Our Ref: R/151/11/NMA

Application for a non material amendment following a grant of planning permission
R/39/10 – 3 Westlands, Rustington

Please note that the enclosed plan *1225/P01 Revision B* therefore becomes the approved plan for the development.

SIDE
PROPOSED ELEVATIONS
Scale 1:100

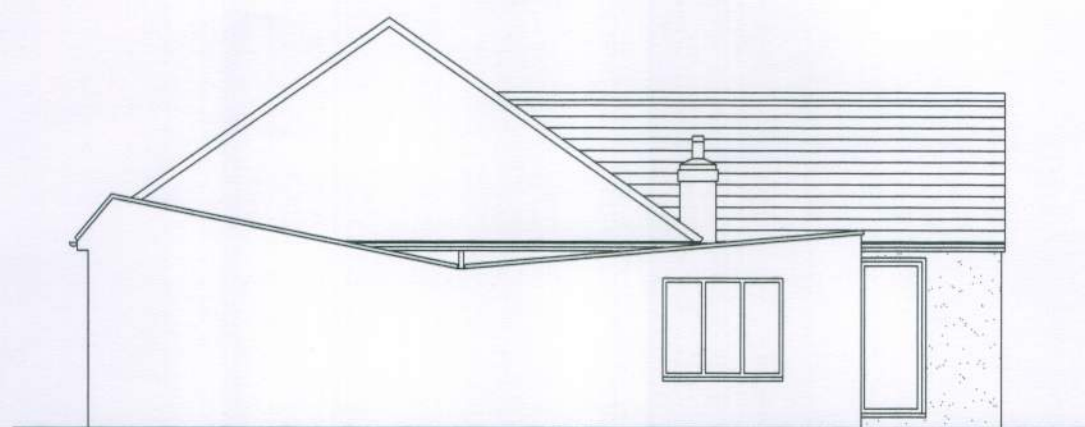
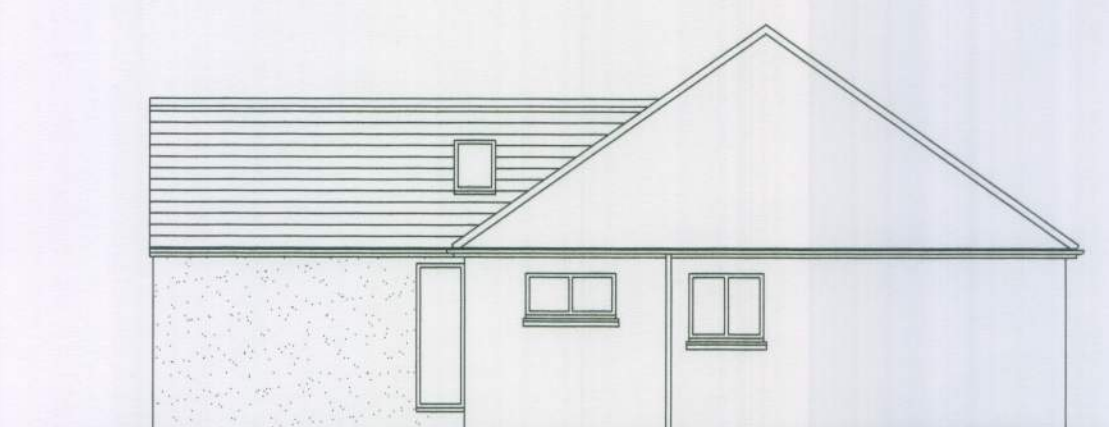
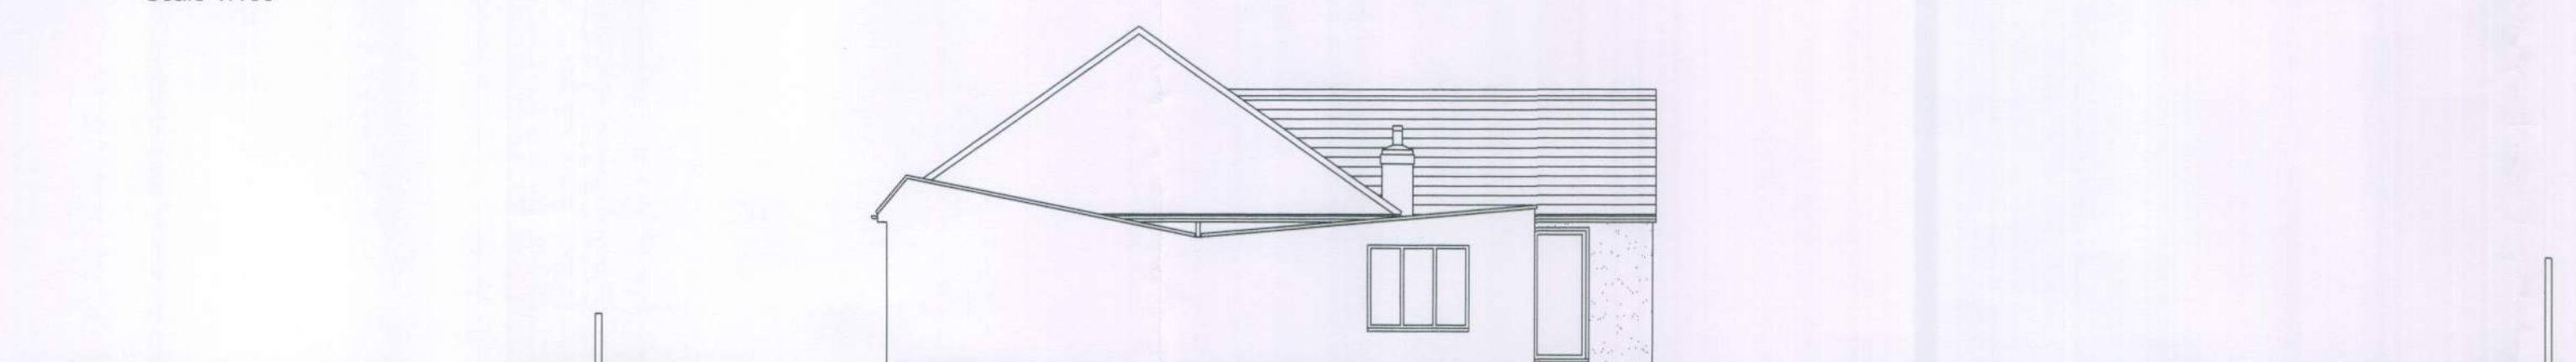
The proposed change of the roof form of the extension from a hipped end to a gable end, as shown in the plans accompanying the application can be accepted as Non-Material Amendments to the previously approved application.
